Sydney Children's Hospital Stage 1 and Children's Comprehensive Cancer Centre

State Significant Development Architectural Report _Addendum
SSD Application - 10831778

SCH-AR-RT-DA058A[A]

September 2021

Scale	Date
1:1500@A1	02/09/21
Drawn By	Checked By
AV	BB
Project No	Revision
	L
Drawing No	19101
SCH1-AR-DG-SSD040

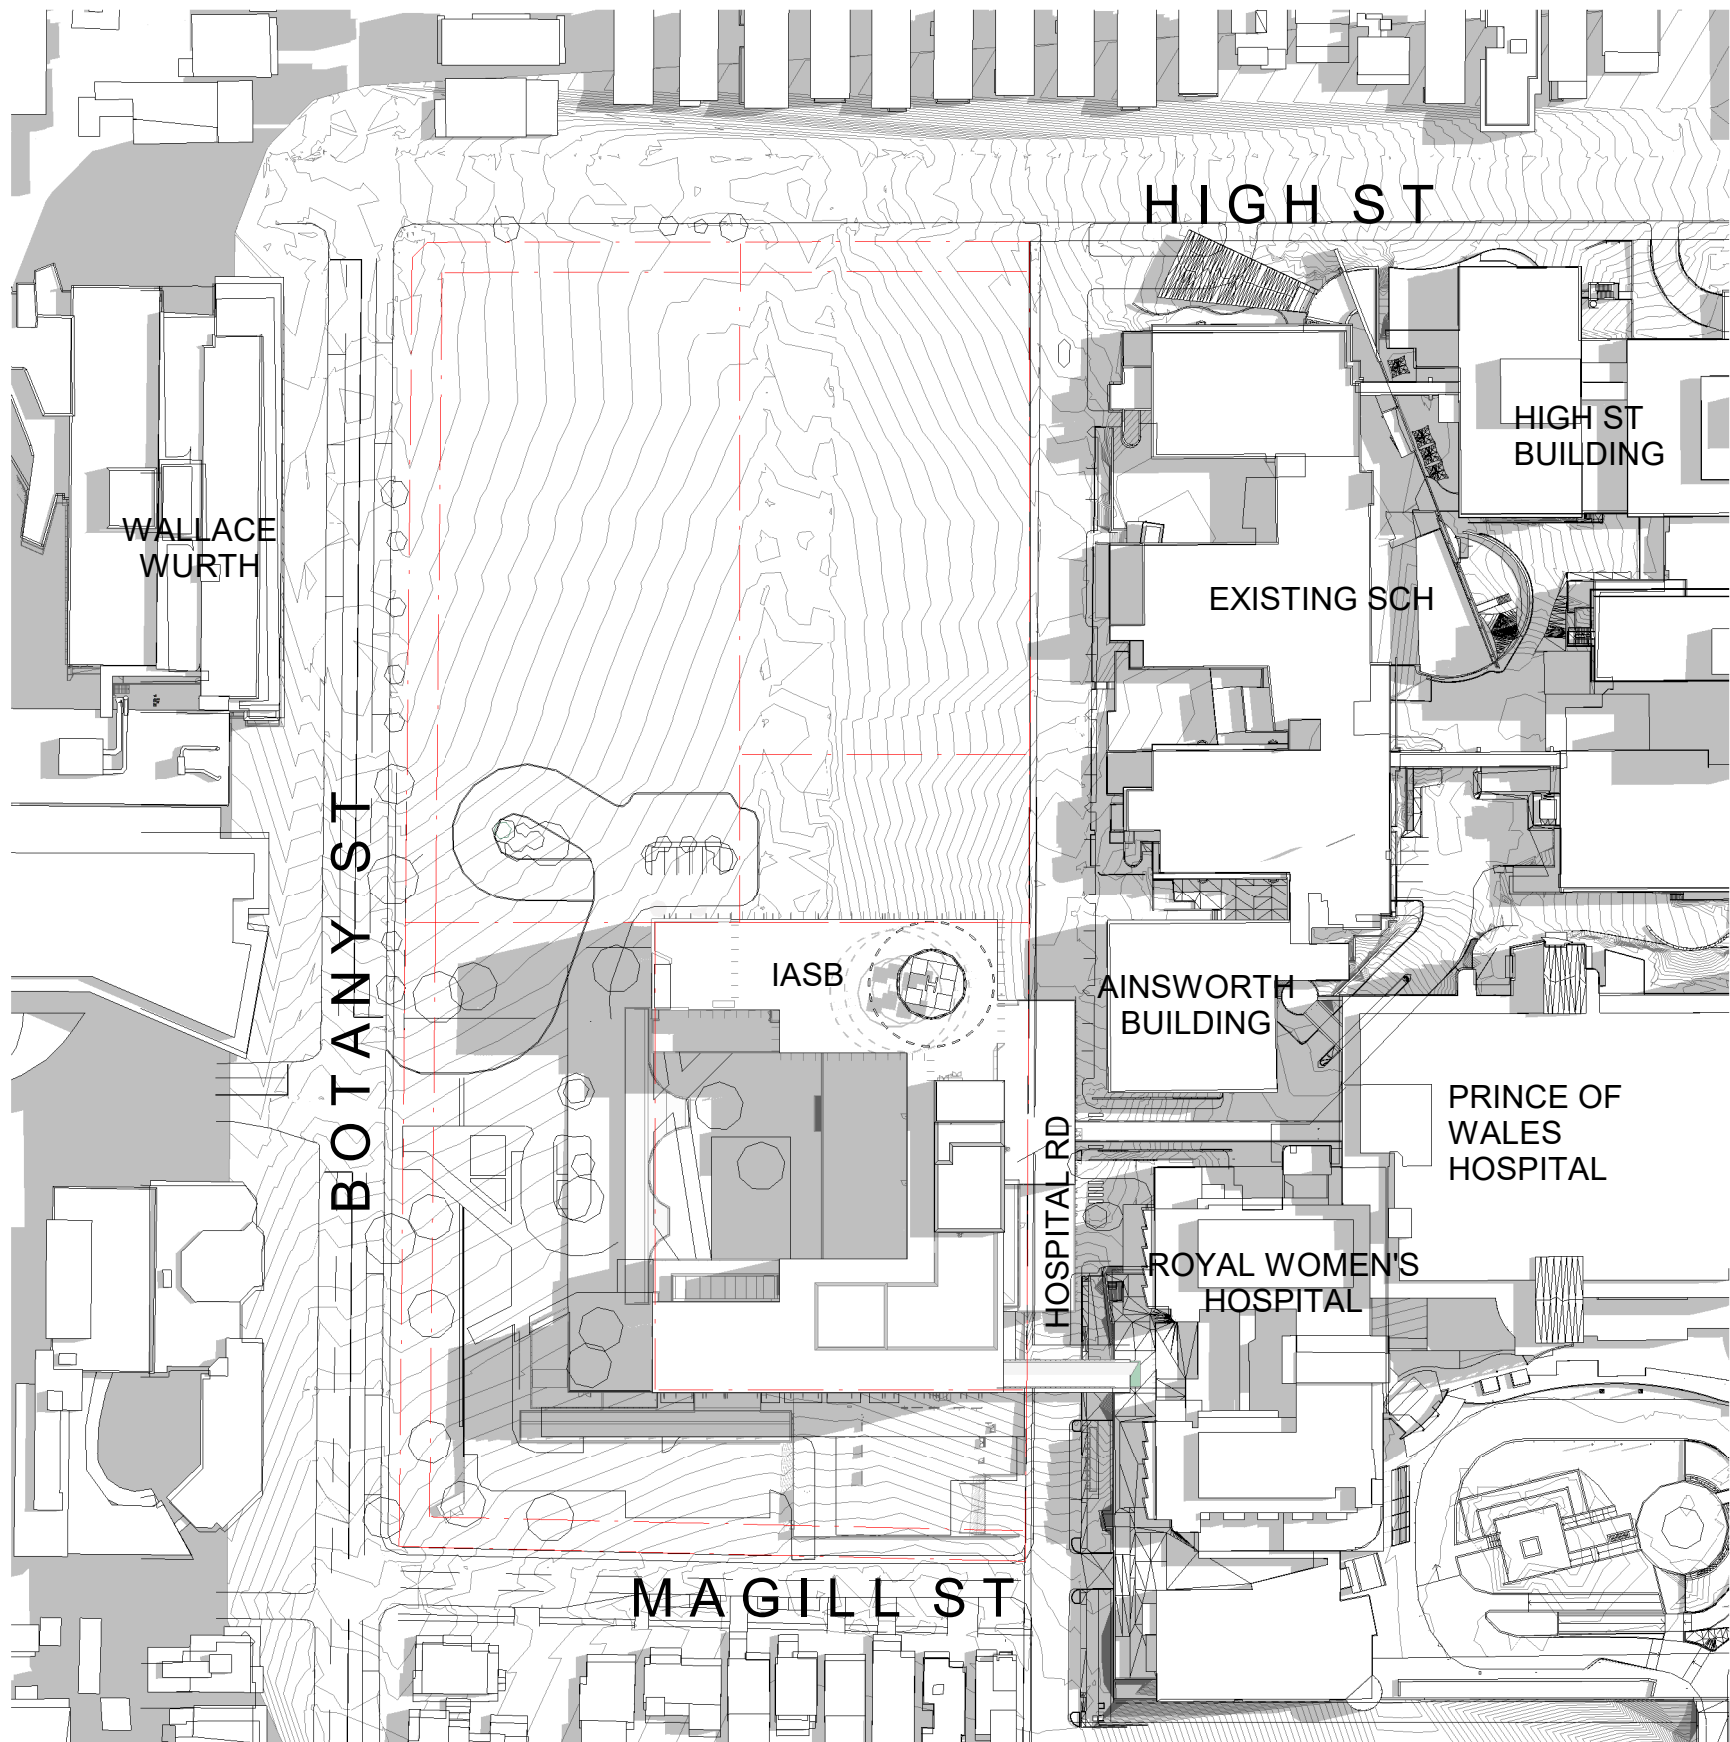
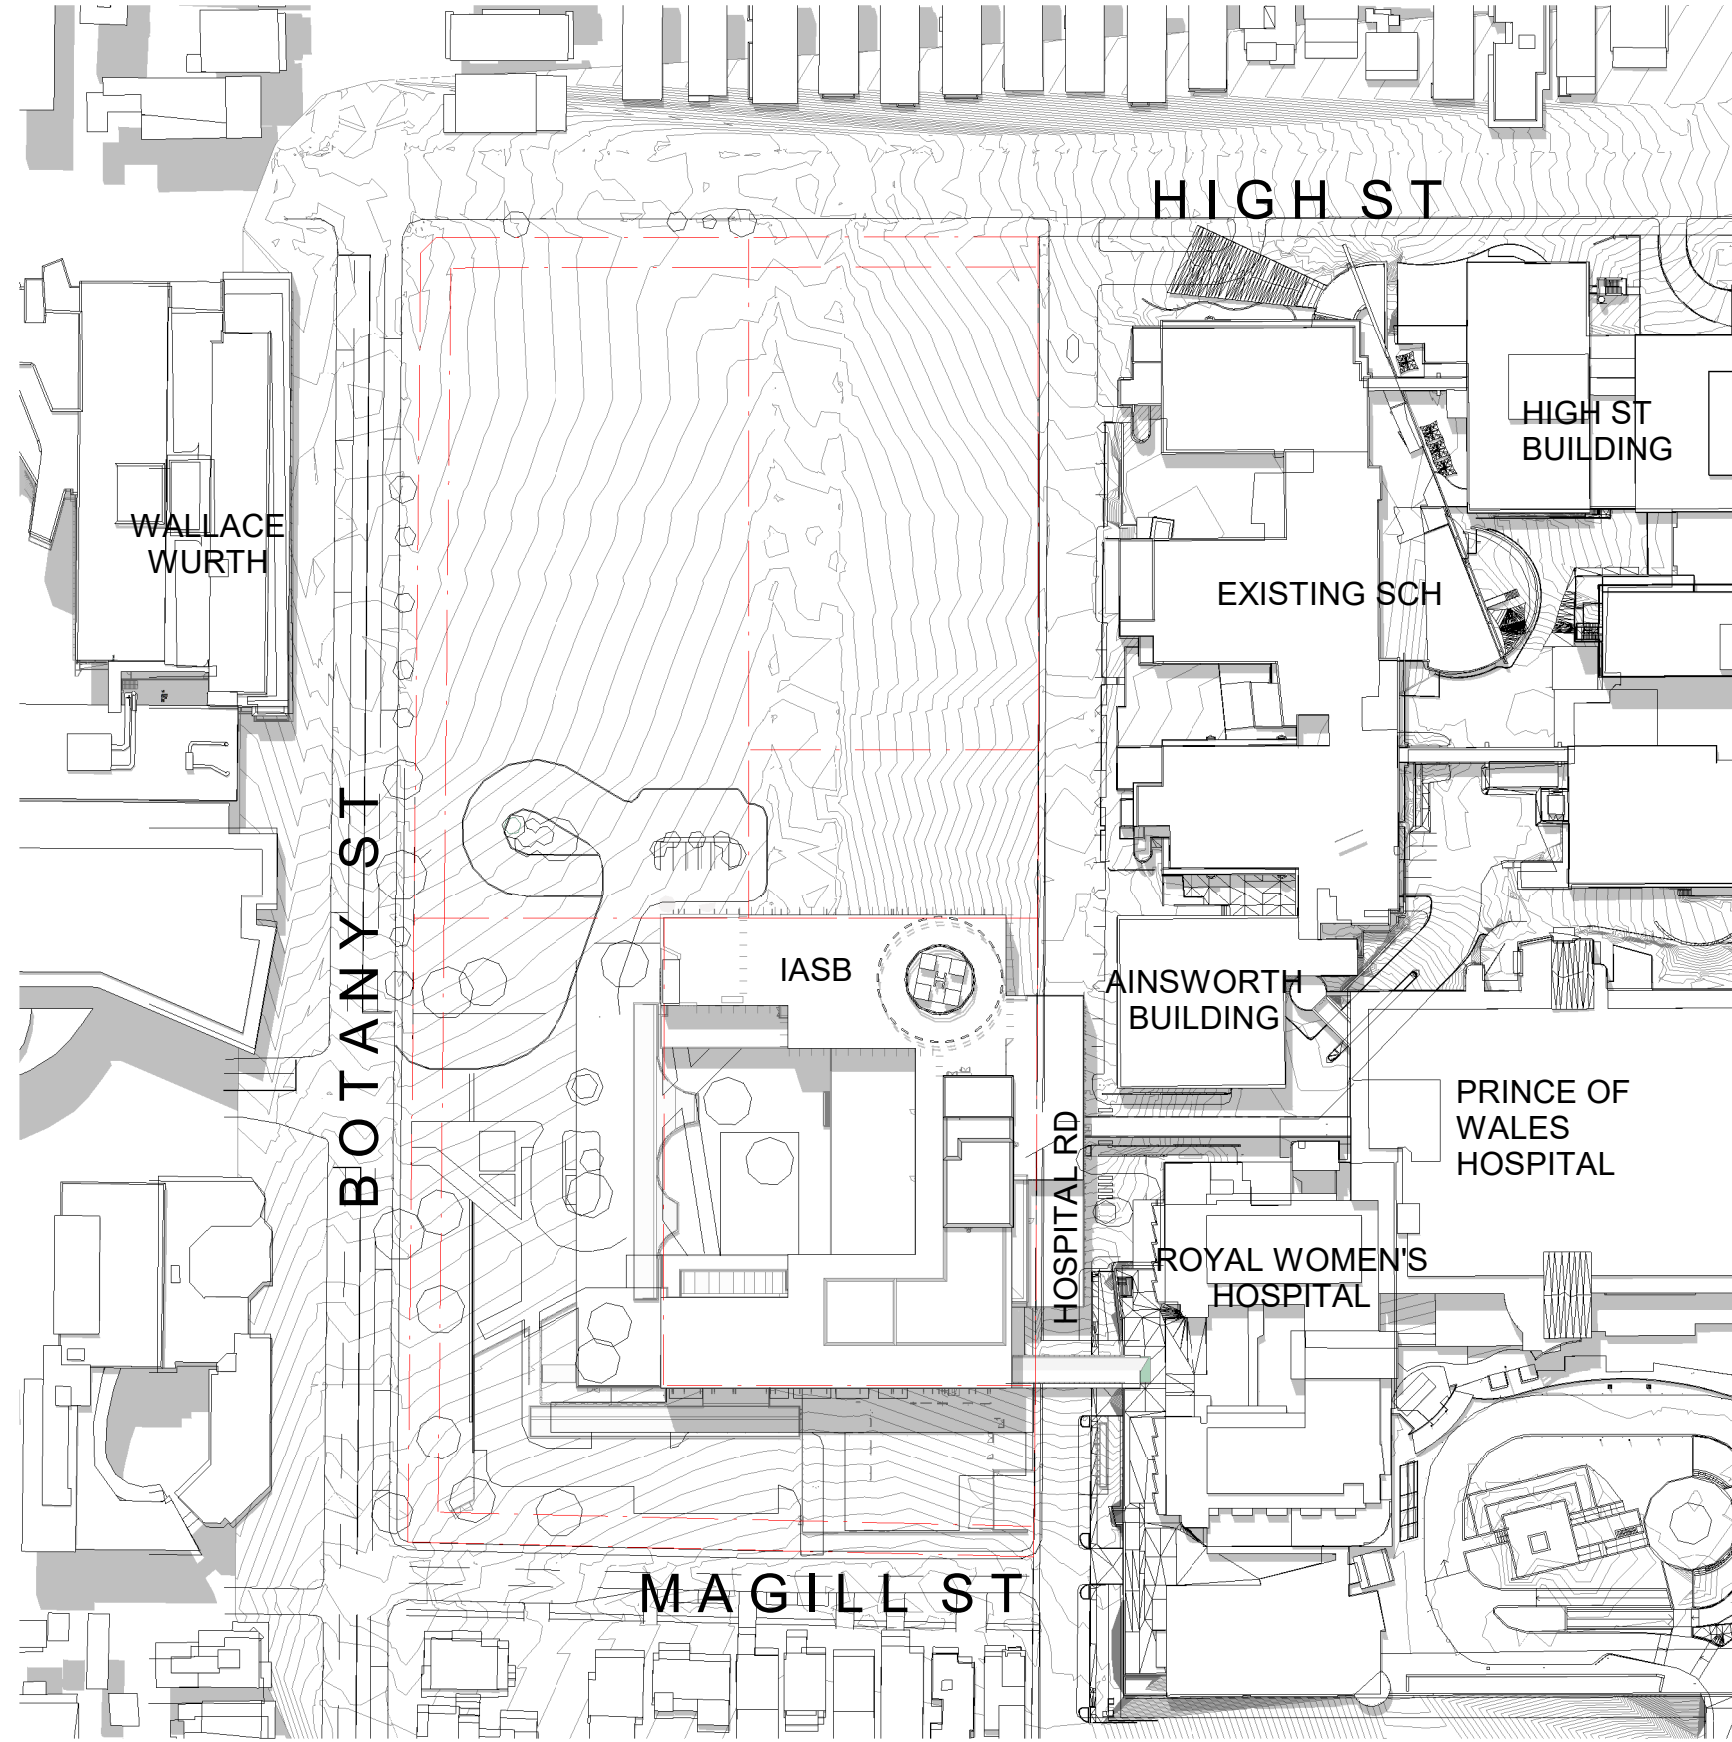
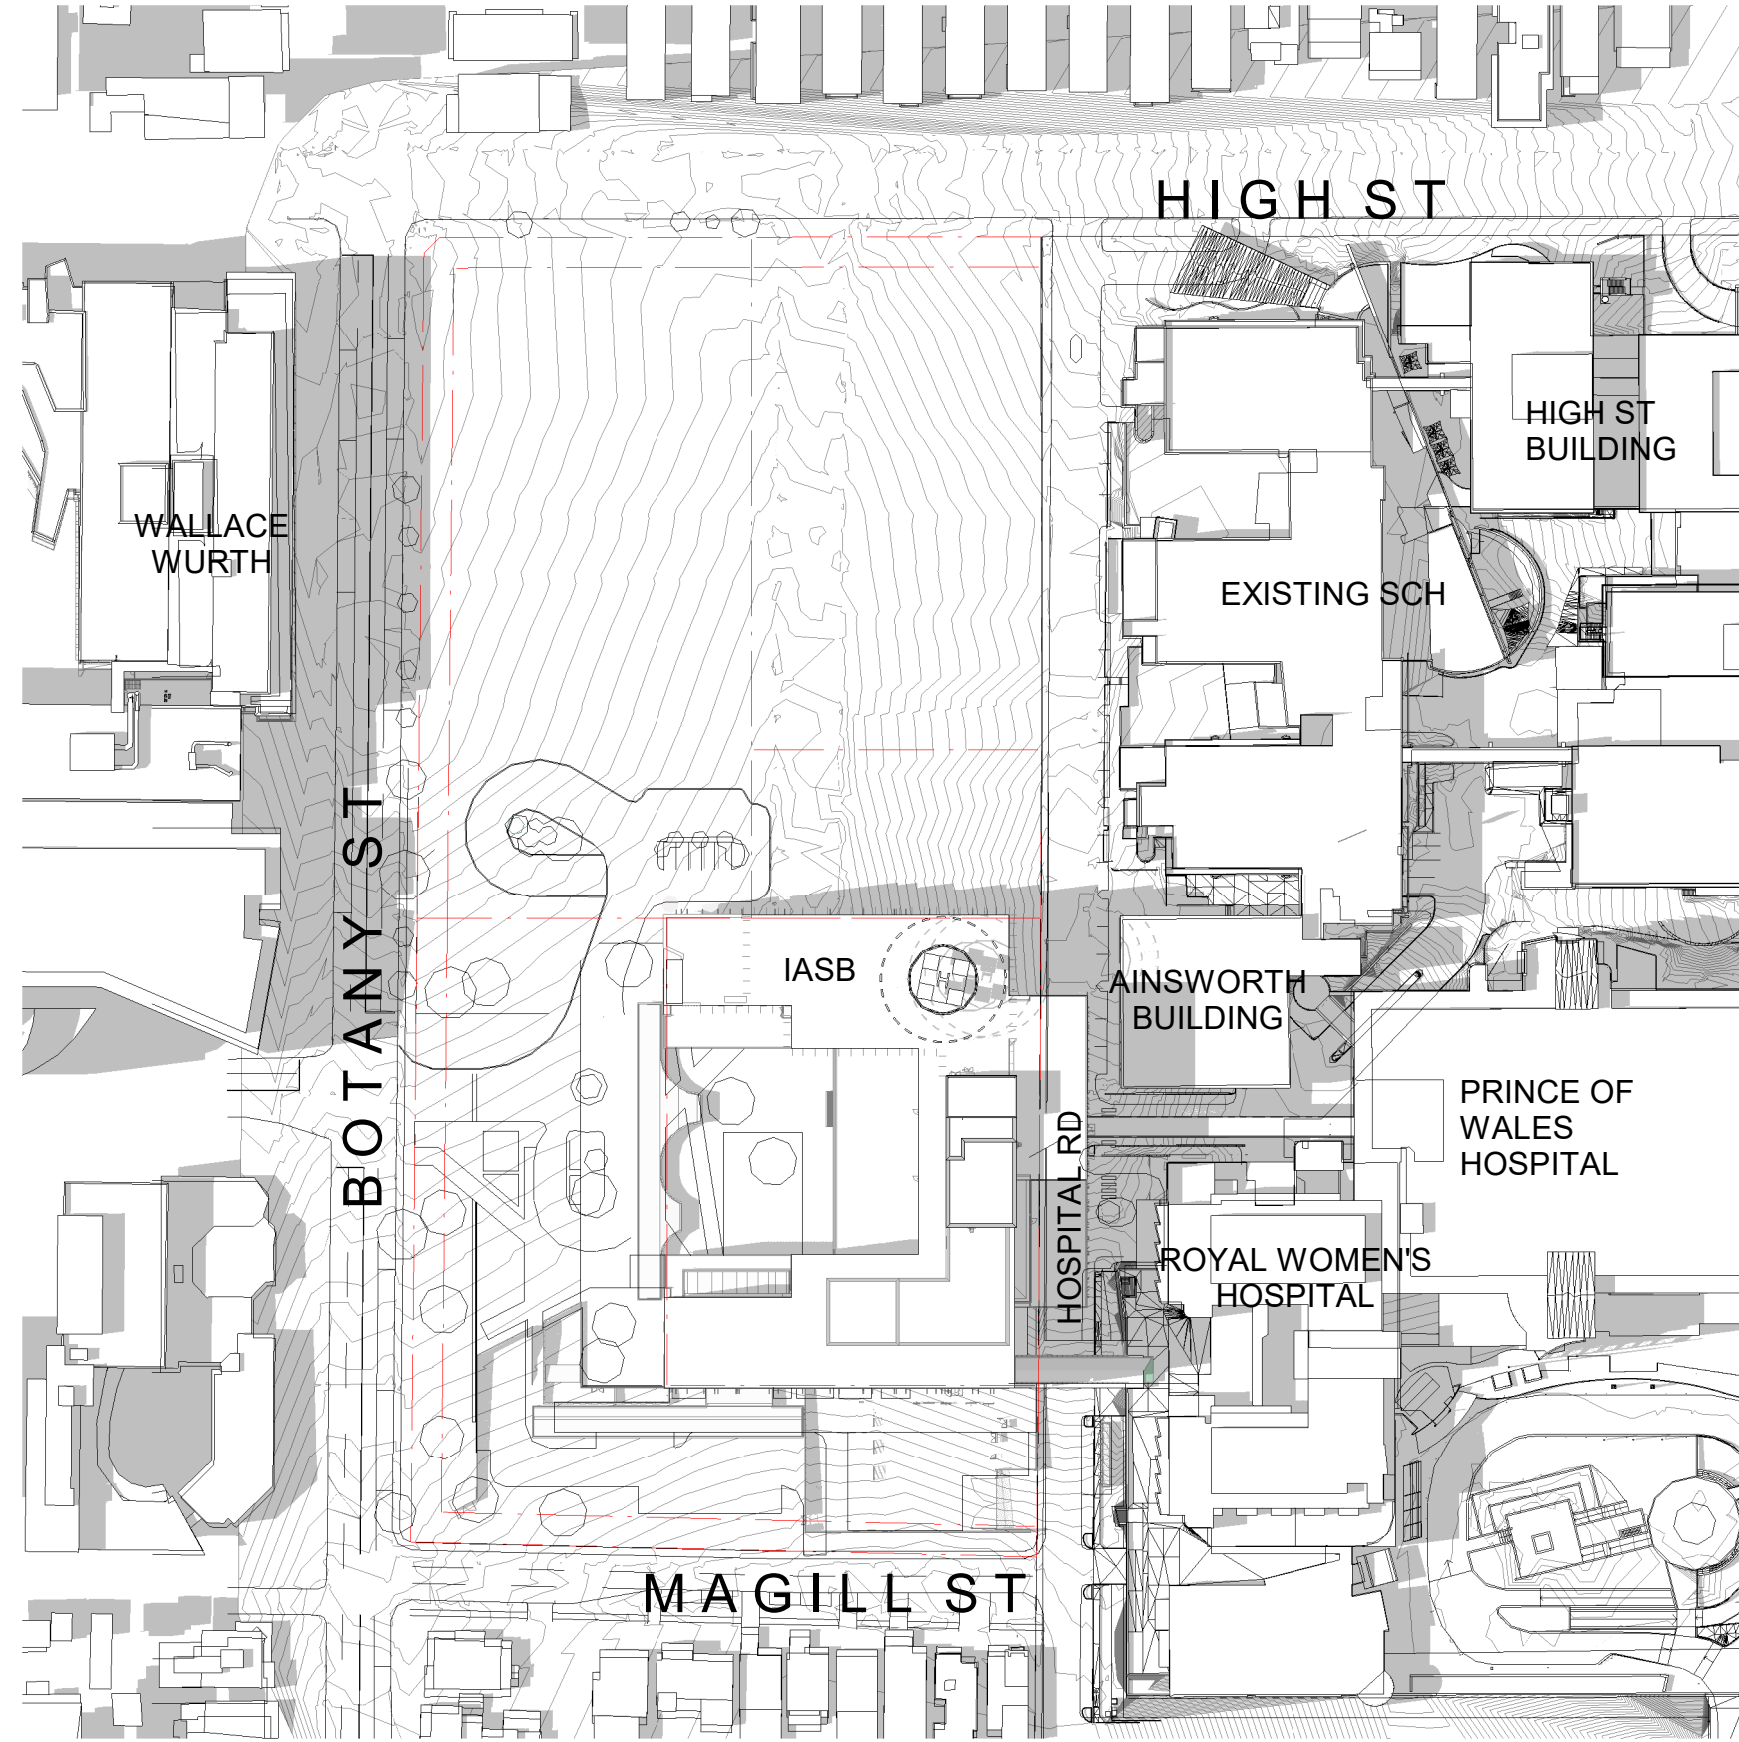
<p>A further concern is the significant overshadowing of this arrival area throughout the year and particularly in winter. This contrasts with the current sunny north facing High Street entry. Additional information and detailing is required to demonstrate how this waiting space will be treated to provide a warm and inviting arrival experience and safe waiting area for parents and children, given the constraints outlined above.</p>	<p>Functional adjacencies have required the Emergency Department to be located on Level B1, with access provided via the Botany Street entry.</p> <p>Competing requirements for access to not only the Emergency Department, but also the IASB and the HTH have all been considered in the design of this shared vehicular entry and drop off point.</p> <p>The design of the Emergency Department itself is based on required functional adjacencies and workflows and ensures a clear arrival point and clear and direct access to Triage as a key functional priority.</p> <p>BLP have provided updated additional renders demonstrating clear access and amenity to the Emergency Department reception. Refer to Appendix A of this report</p> <p>Internally, opportunities for integration of public art will be investigated.</p> <p>Refer to architectural drawings, for additional internal detail of Emergency Department.</p> <p>Refer to architectural drawings SCH1-AR-DG-SDD040, SCH1-AR-DG-SDD041, SCH1-AR-DG-SDD042 and SCH1-AR-DG-SDD043.</p>
